RETREAT AT TIMBERRIDGE FILING NO. 4

CONSTRUCTION DRAWINGS

FEBRUARY 2024

EPC STORMWATER REVIEW COMMENTS
IN ORANGE BOXES WITH BLACK TEXT

RETREAT AT TIMBERRIDGE FILING NO. 4 CONSTRUCTION DRAWINGS TITLE SHEET			
DESIGNED BY	PRA	SCALE	DATE 2-29-24
DRAWN BY	PRA	(H) 1" = N/A	SHEET 1 OF 14
CHECKED BY		(V) 1" = N/A	JOB NO. 1185.31

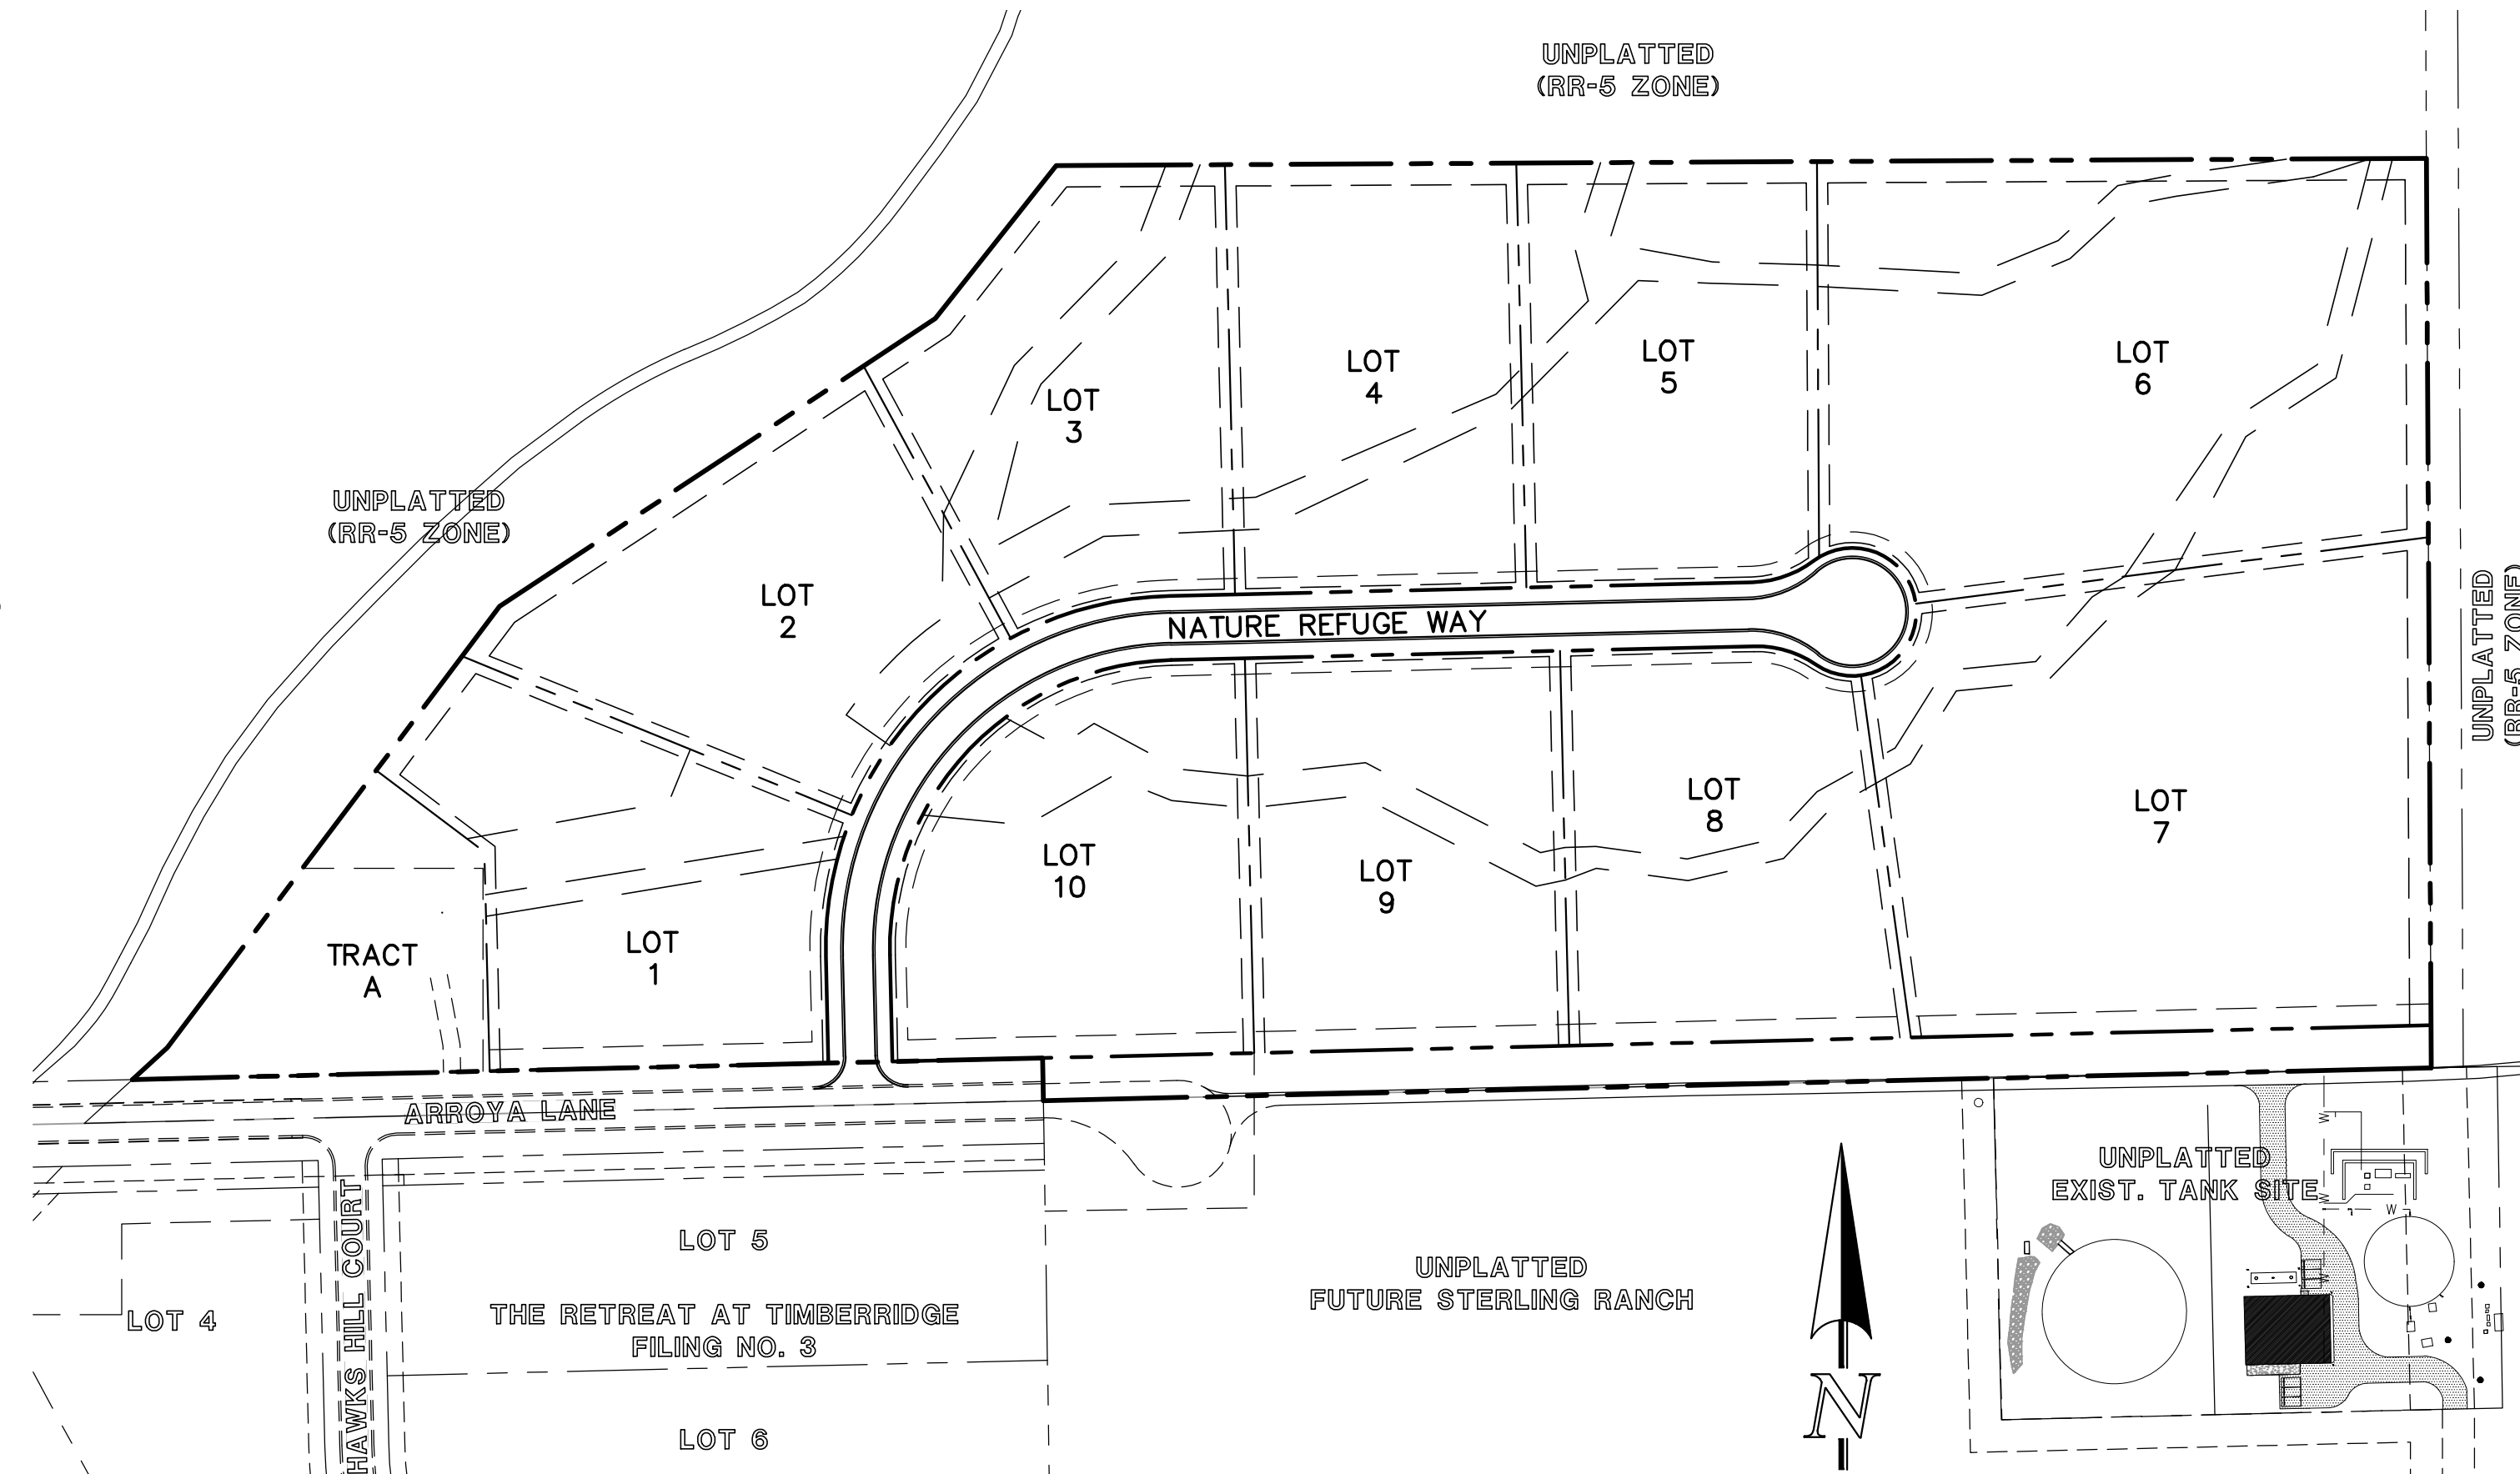
Since the GEC Plan is within the CDs, no need to submit the GECs separate for future submittals

"of the grading and erosion control plan and all of the requirements specified in these detailed plans and specifications." Match the GEC Checklist signature
